COLORADO GEOLOGICAL SURVEY

November 28, 2017

Subject: Springs East at Waterview, Preliminary Plan (SP-17-010)
El Paso County, CO; CGS Unique No. EP-18-0011

Computer File Information	
Creation Date: 4-3-17	Initials: CMD
Last Modification Date: 10-16-18	Initials: JM 10/17/18
Full Path & Drawing File Name: V:\1817\active\181710214\CAD\Plansheets Grading Plan	
Acad Ver. 2014	Scale: see plan Units: Feet

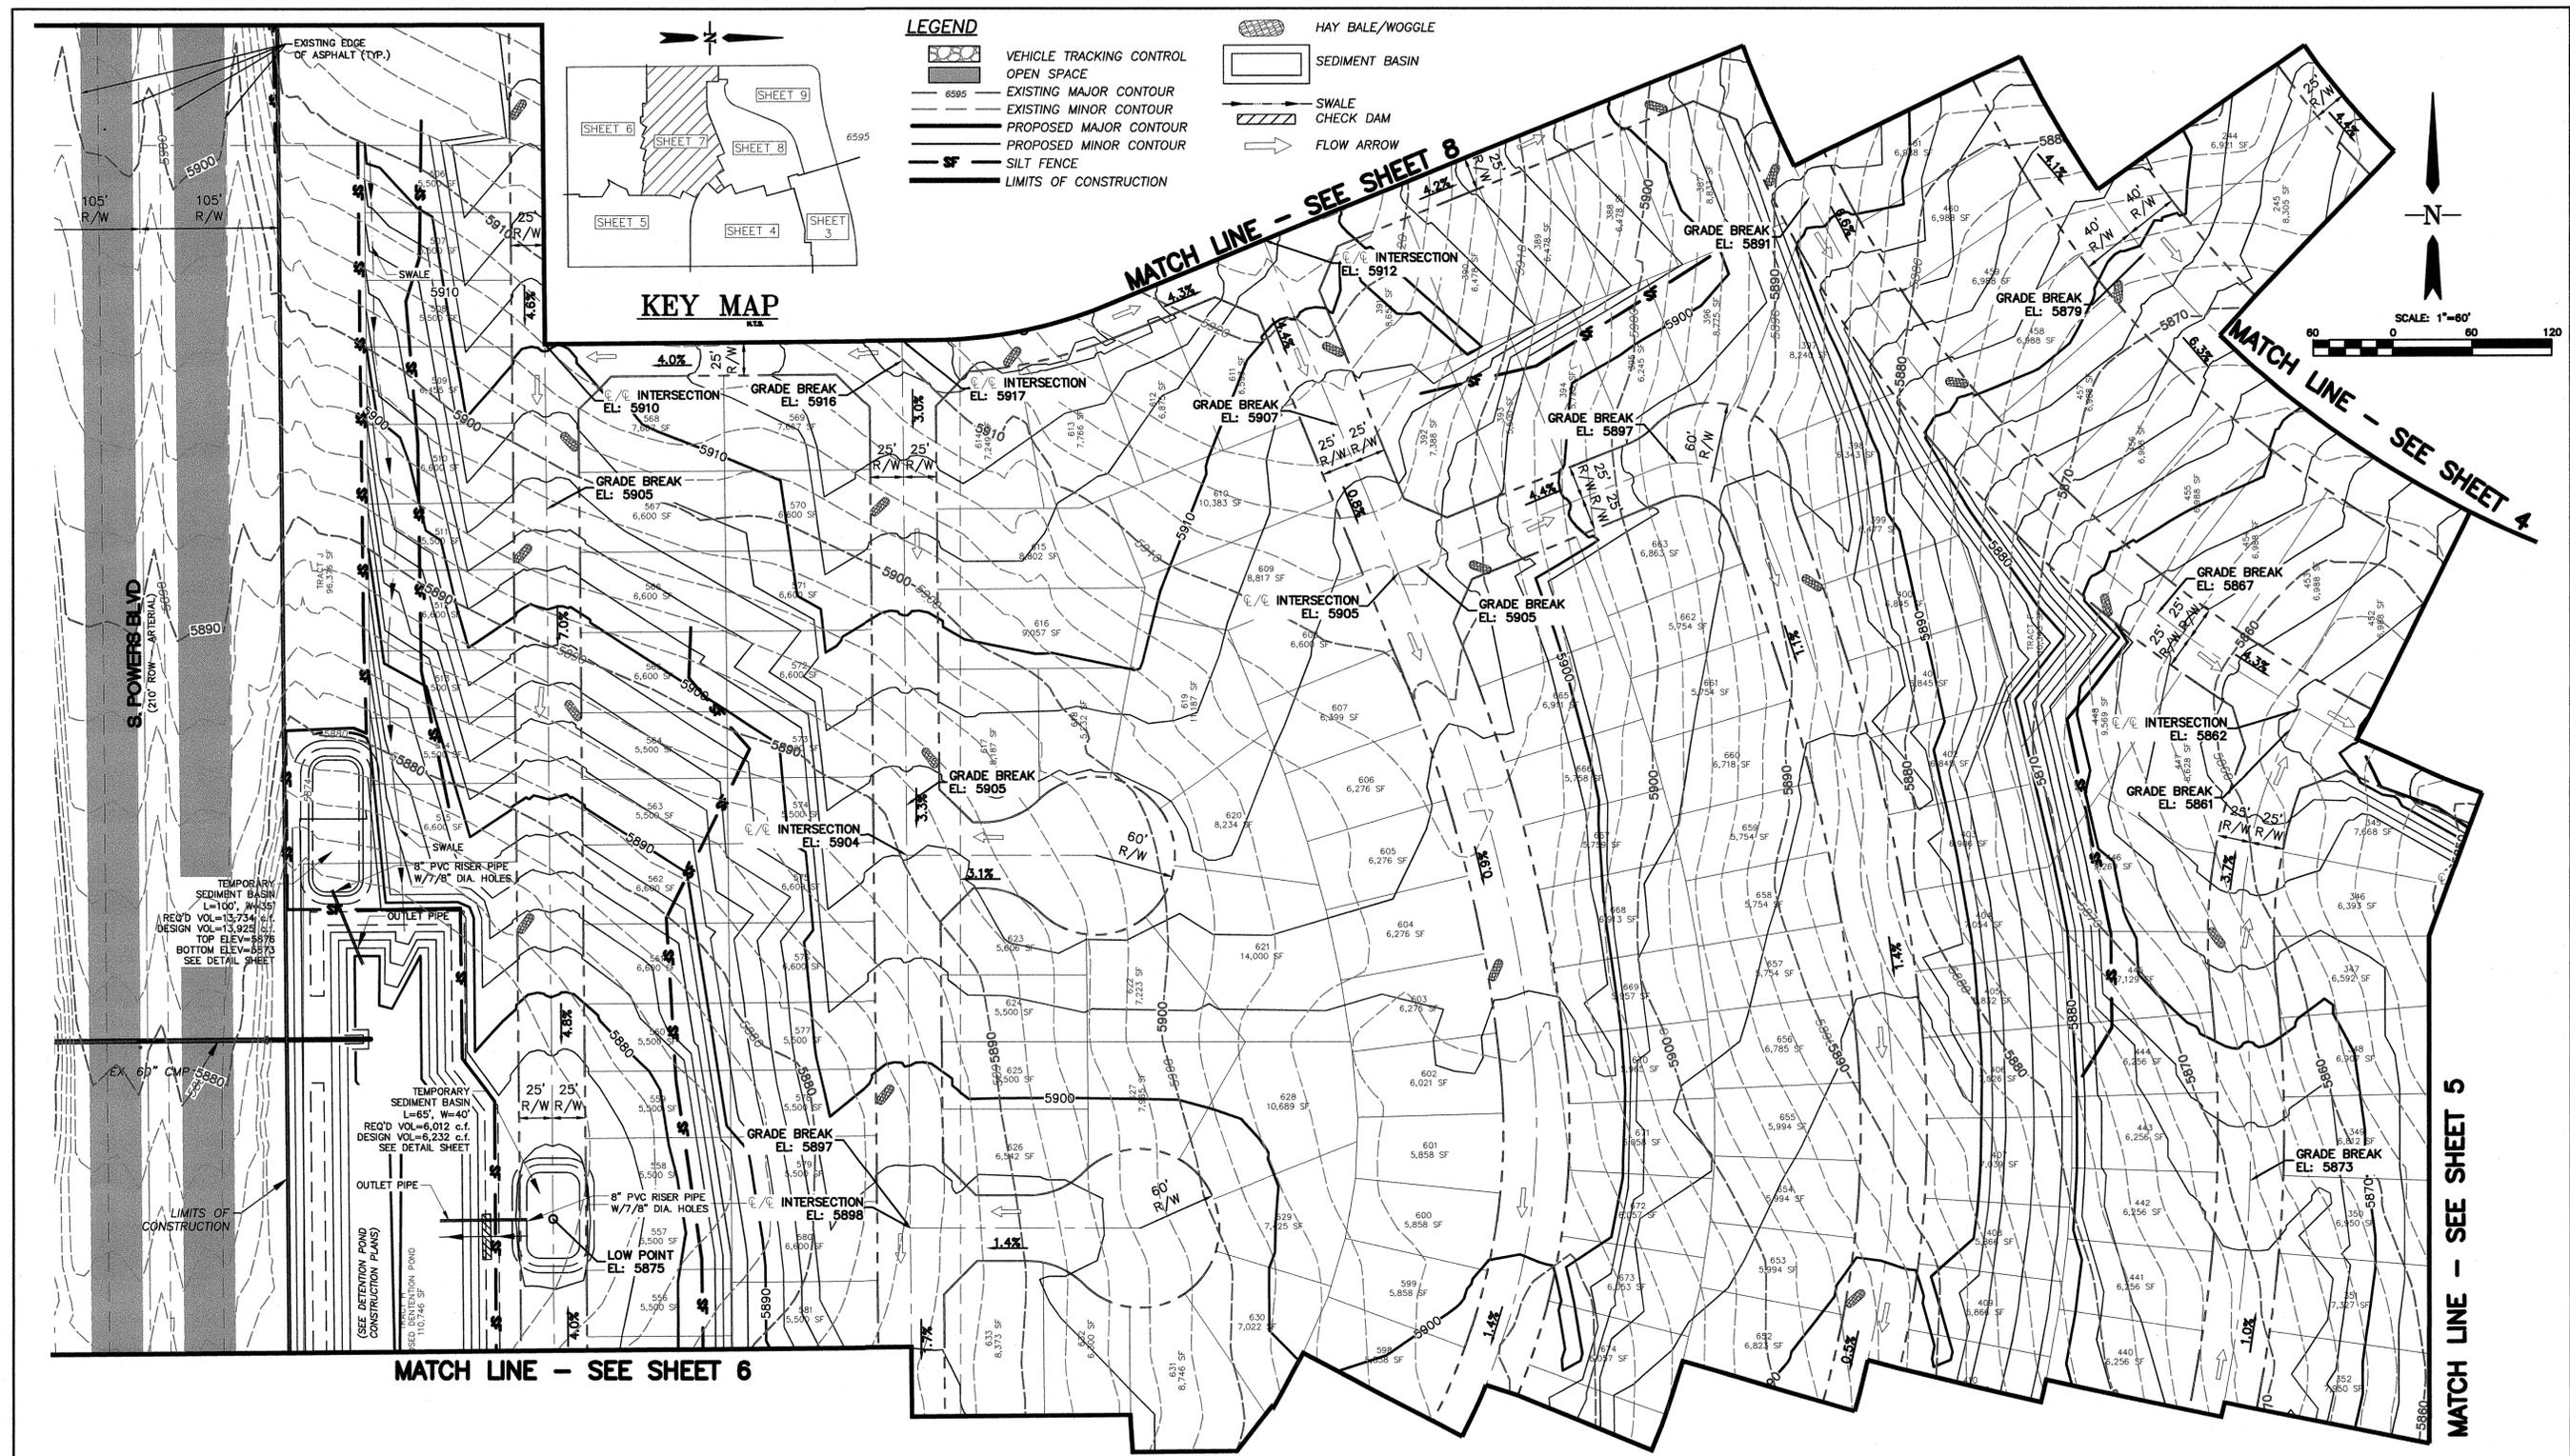
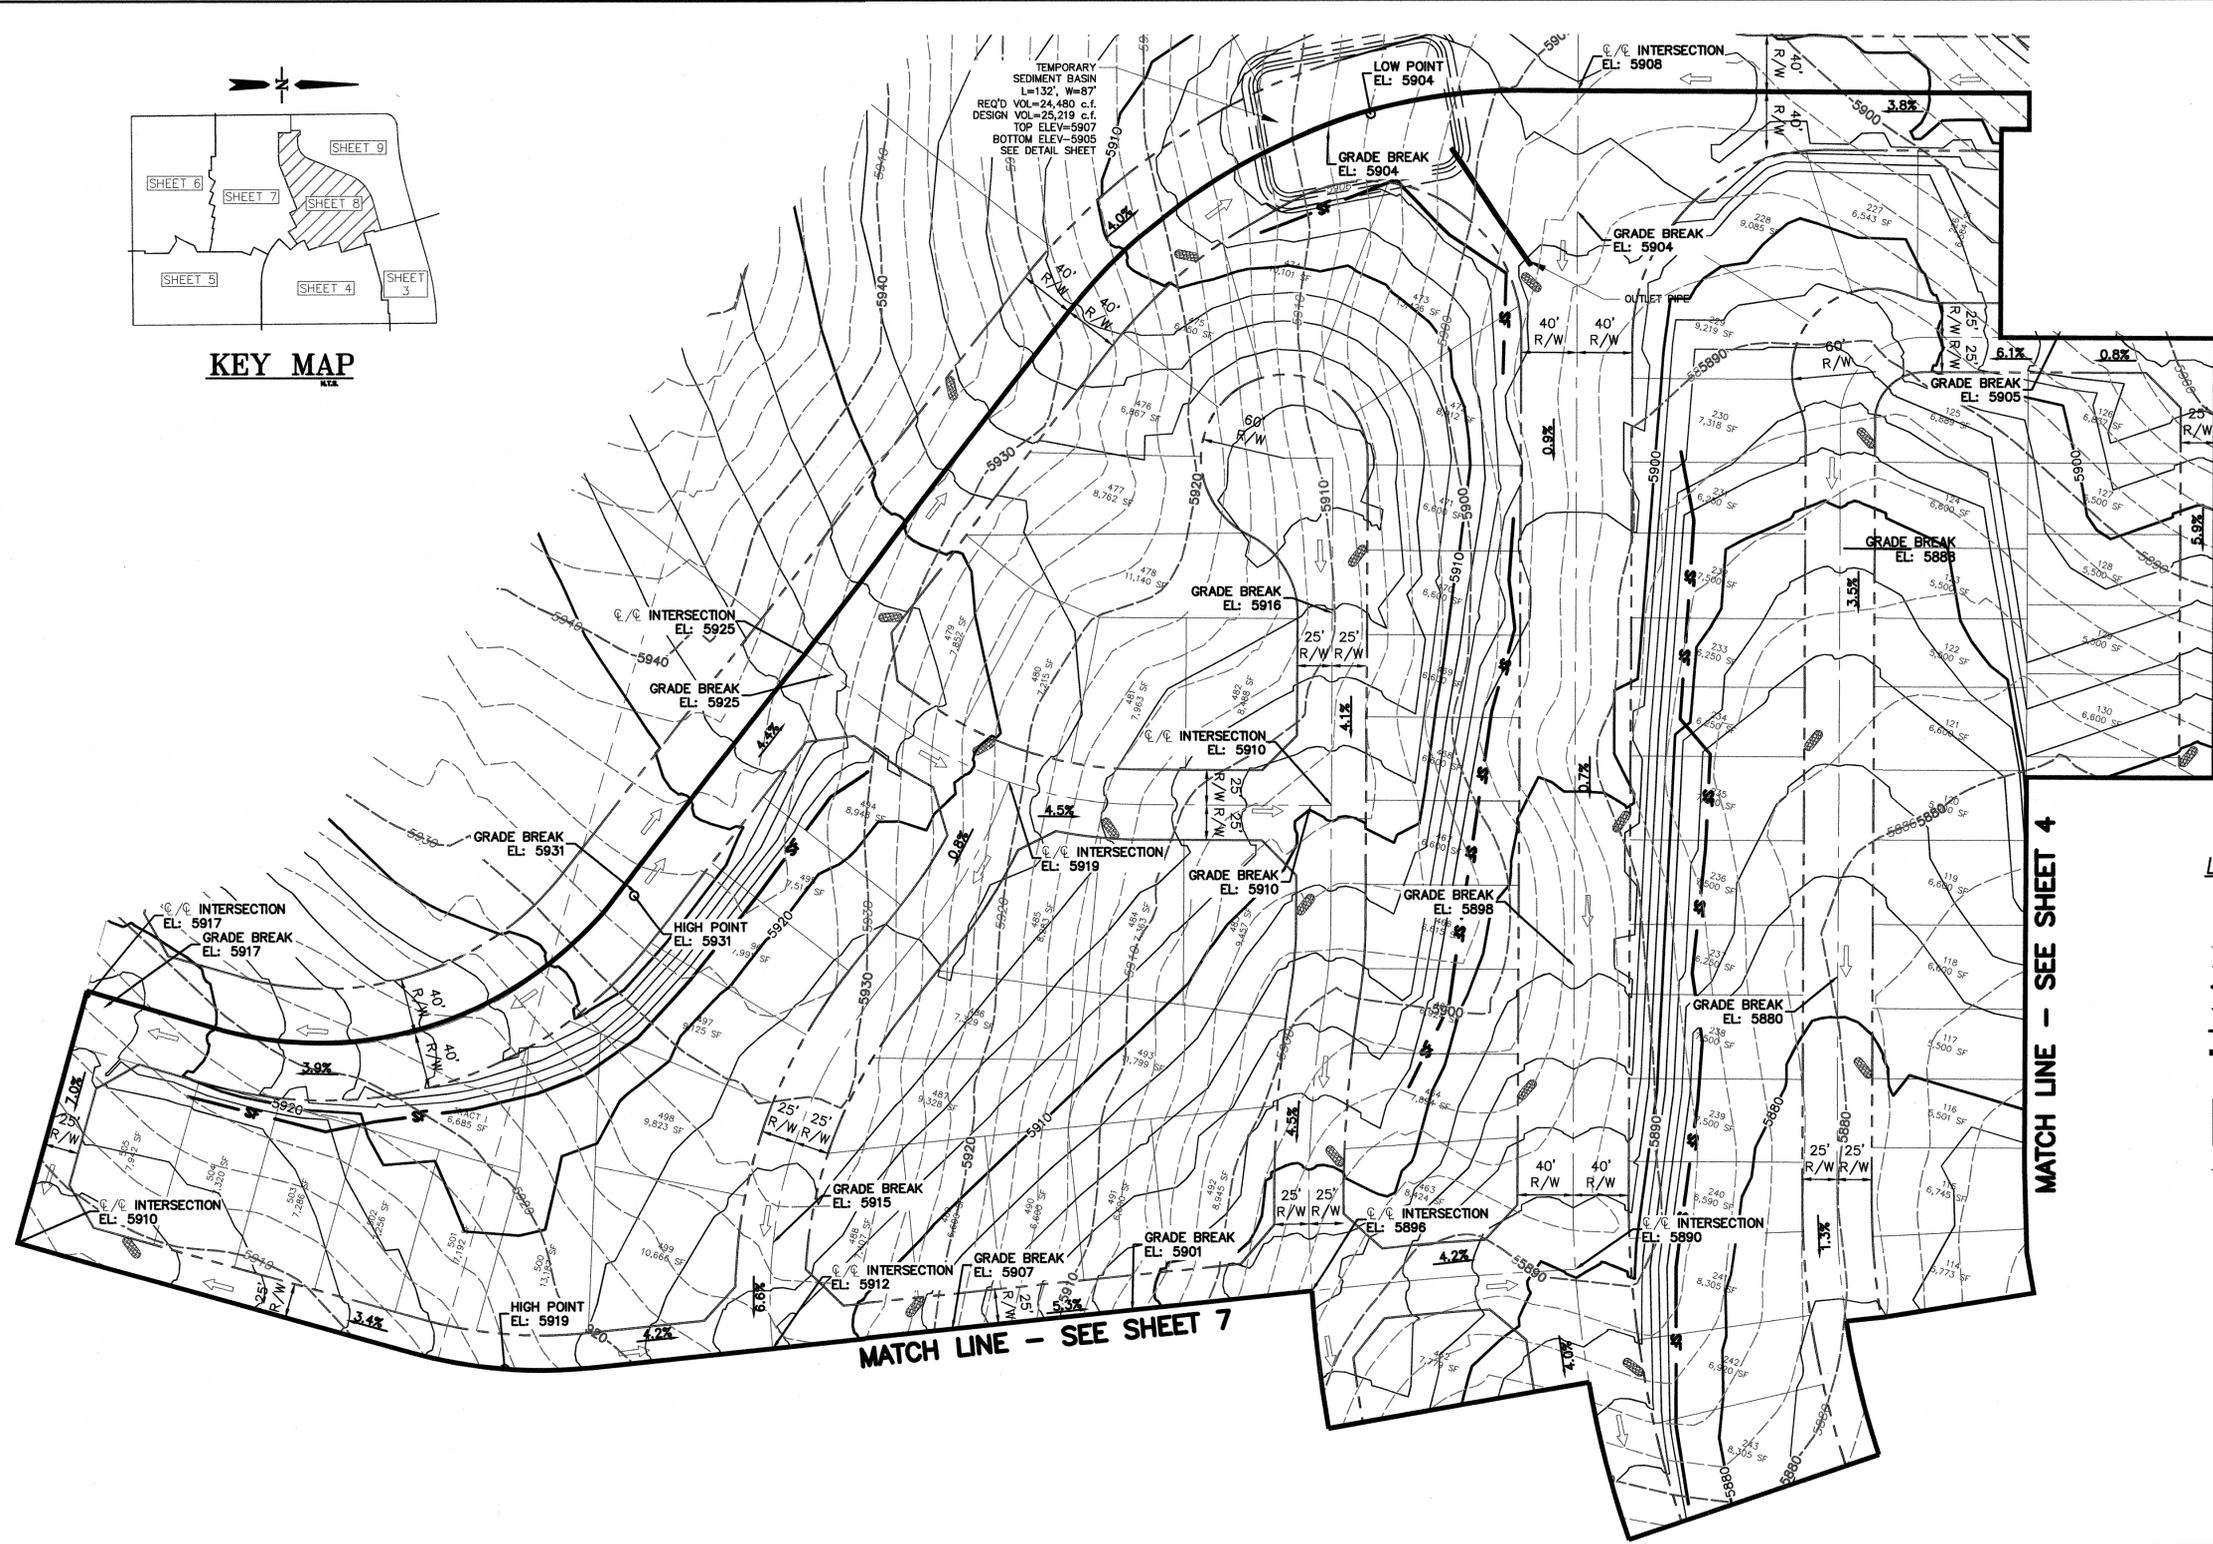
Entech's ten borings were drilled to a depth of 20 feet. The Waterview East Grading and Erosion Control Plan (Stantec, April 3, 2017) indicates that significant cuts and fills are planned, with cuts exceeding 20 feet in some areas. Some of Entech's borings, including but not necessarily limited to TB-1 in the northeastern area of the site, therefore may not extend to sufficient depths to provide meaningful information about soil and bedrock engineering properties and groundwater levels. Additional investigation, sampling, testing and analysis are needed, based on the project grading plans, to characterize subsurface conditions, determine depth and extent of overexcavation, if overexcavation is planned to reduce the use of drilled pier foundations, and to determine basement feasibility in areas of significant cuts where Entech's borings did not extend to sufficient depth below planned basement floor and foundation bearing depths.
